Applicant: Albion Land

Proposal: Discharge of Condition 9 - (route of service connections) of 21/03177/F

- Proposed Utilities Layout (ref: 1746-ESC-ZZ-ZZ-DR-Z-1000 T1)

Project  
**Axis J9  
 Bicester  
 Phase 3**  
 Drawing Title  
**Proposed Utilities Layout**

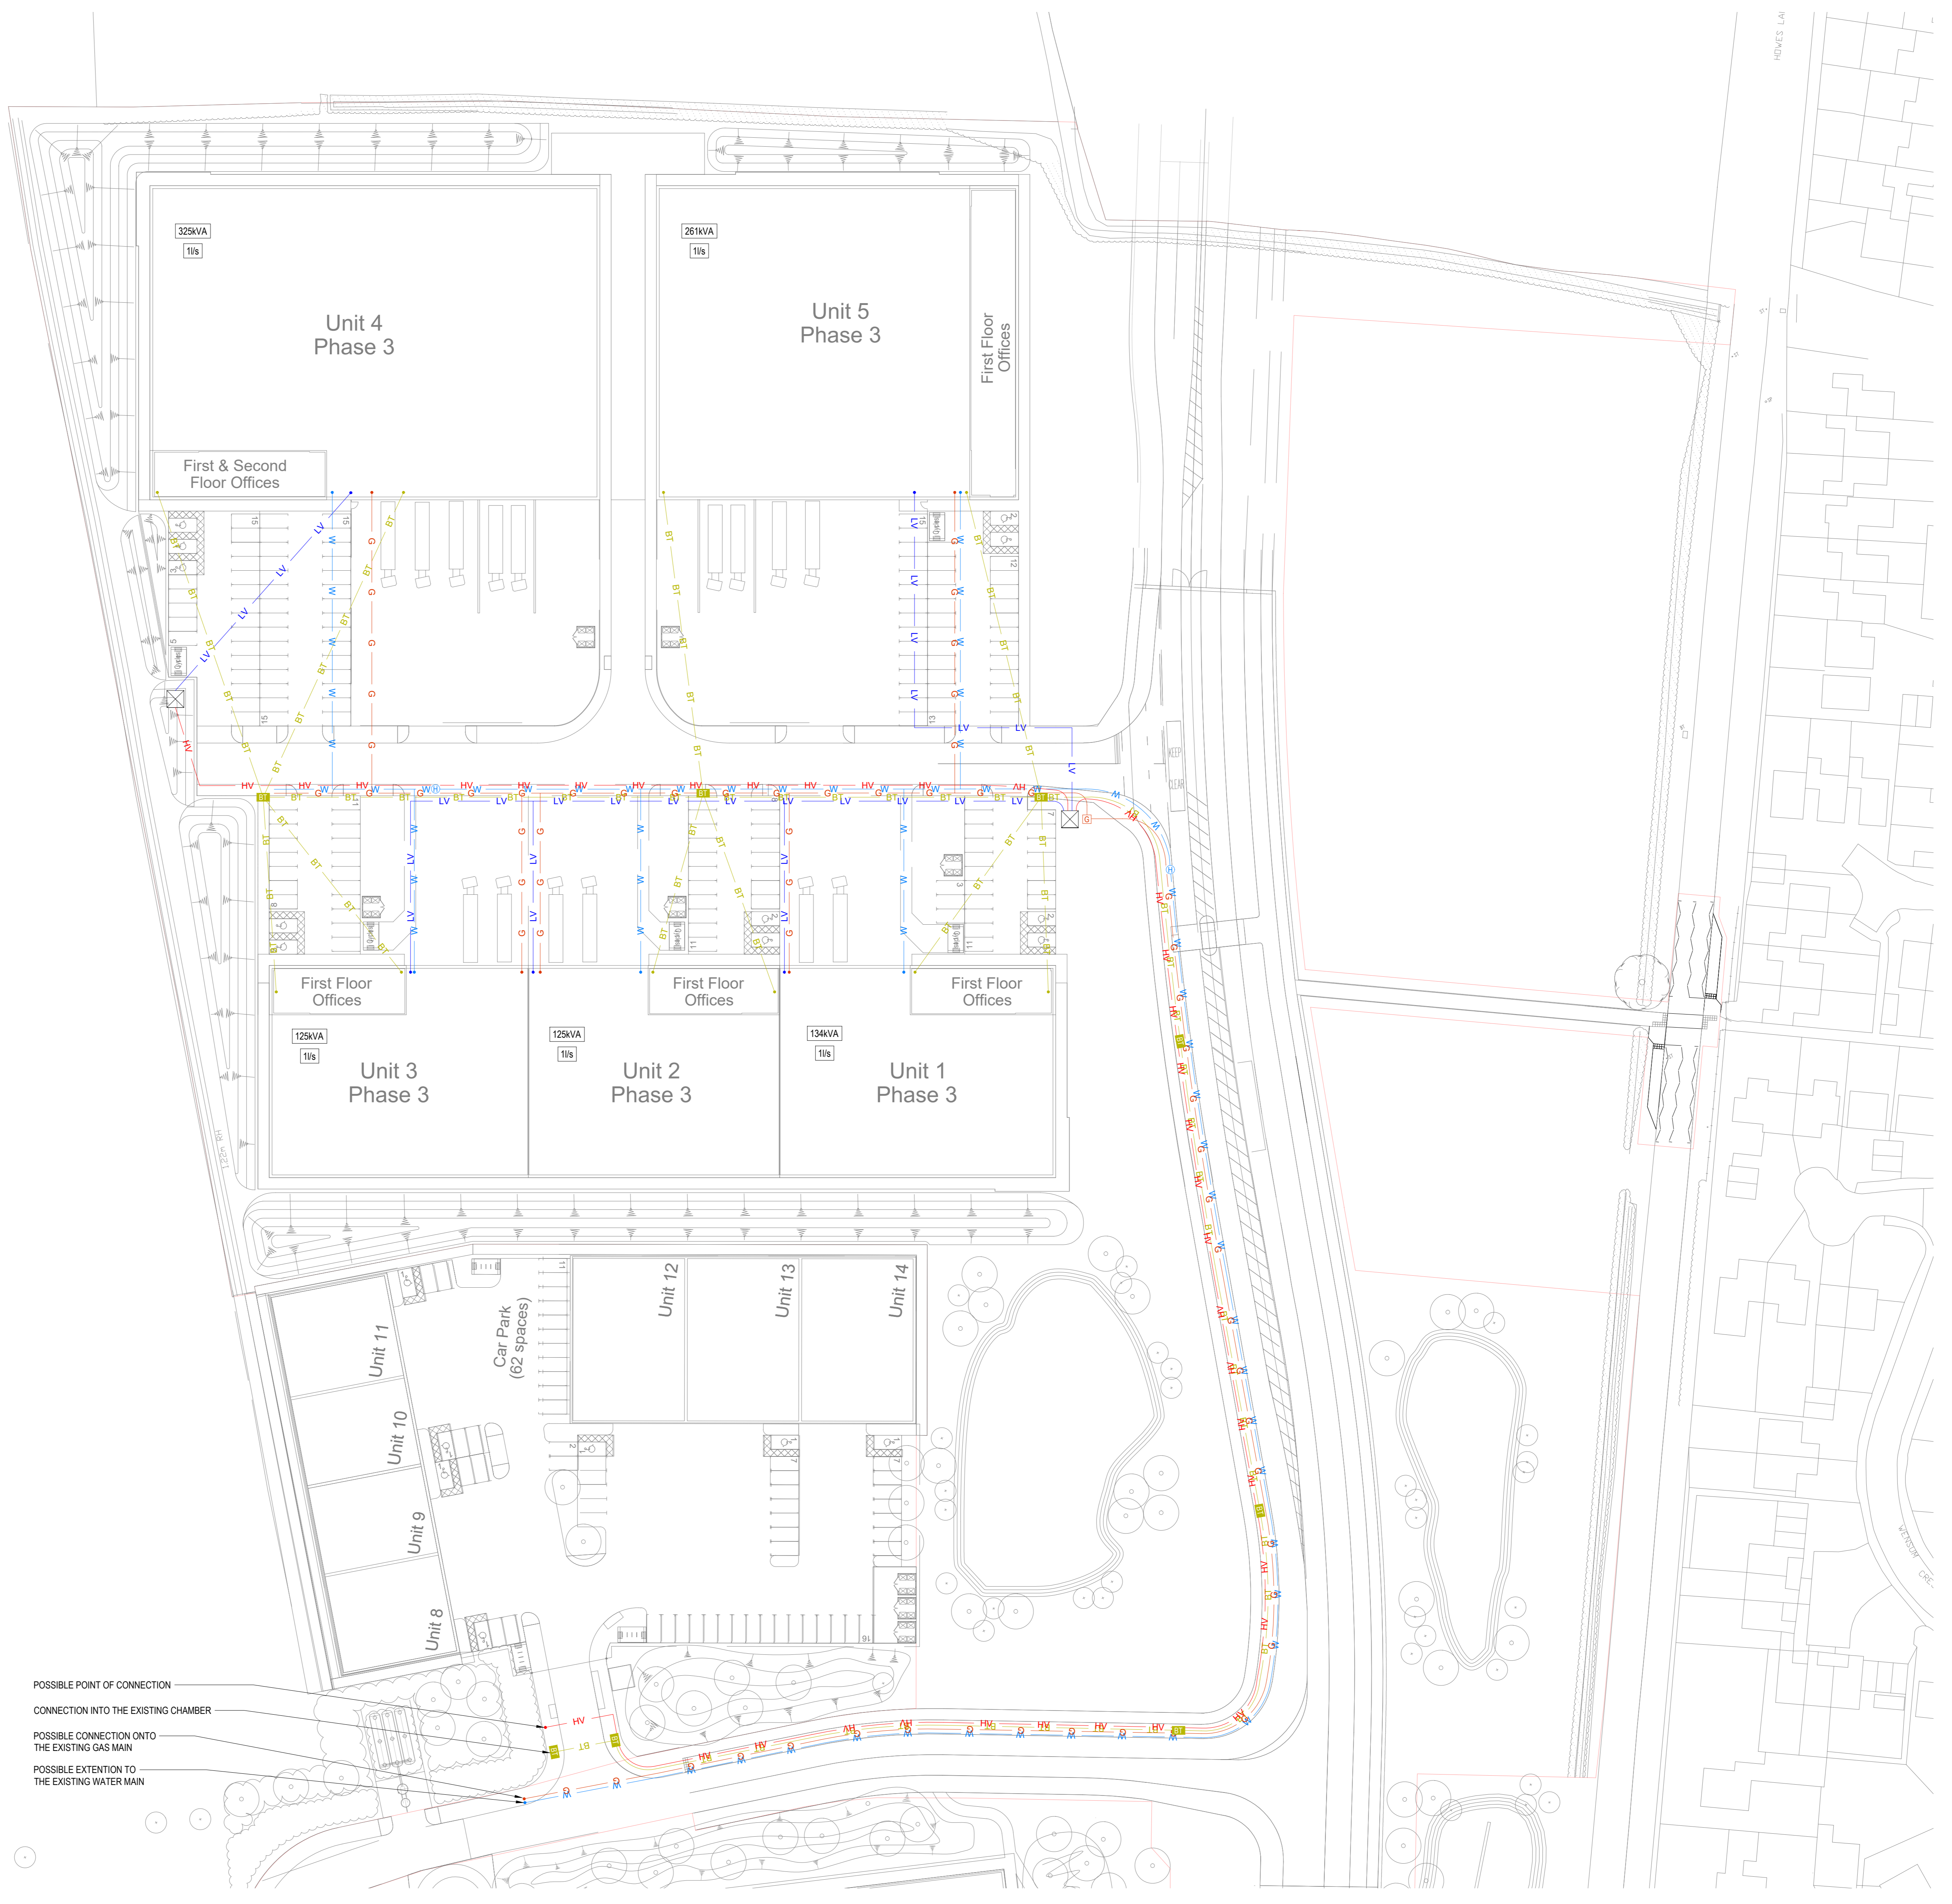
- 5.1. National Grid: No comments to make.
- 5.2. NPCU: No comments received.
- 5.3. OCC Single Response: No objection However, please note that covers should be avoided within the cycle lane or be of a non-slip type.
- 5.4. Southern Gas Network: No comments received.
- 5.5. Thames Water: No comments to make.
- 5.6. Western Power: No comments received.

- 6.3. The presence of gas lines on the plan has been queried given that the use of gas does not form part of the zero carbon approach proposed and it is understood that this would not create a True Zero Carbon development as required by Policy Bicester 1. Gas lines are shown on the approved service connection plans for phases 1 and 2 so what is shown is consistent with that. The development as built would need to comply with the approved arrangements and then ongoing operational monitoring is required which would highlight how the site is being run and any issues could be considered further. The applicant's agent has been reminded of the operational monitoring requirements. As the purpose of the condition relates to character and appearance and a similar arrangement has been approved elsewhere, it is not considered this can now be resisted but ongoing monitoring will be important to ensure the maintenance of the standards at this site.

- 6.2. There are no objections from the main utility providers or the County Council. In addition, the proposal would be acceptable as it would have limited impact on the character and appearance of the area given the utilities routes would be predominantly underground. On this basis, the details may be discharged.
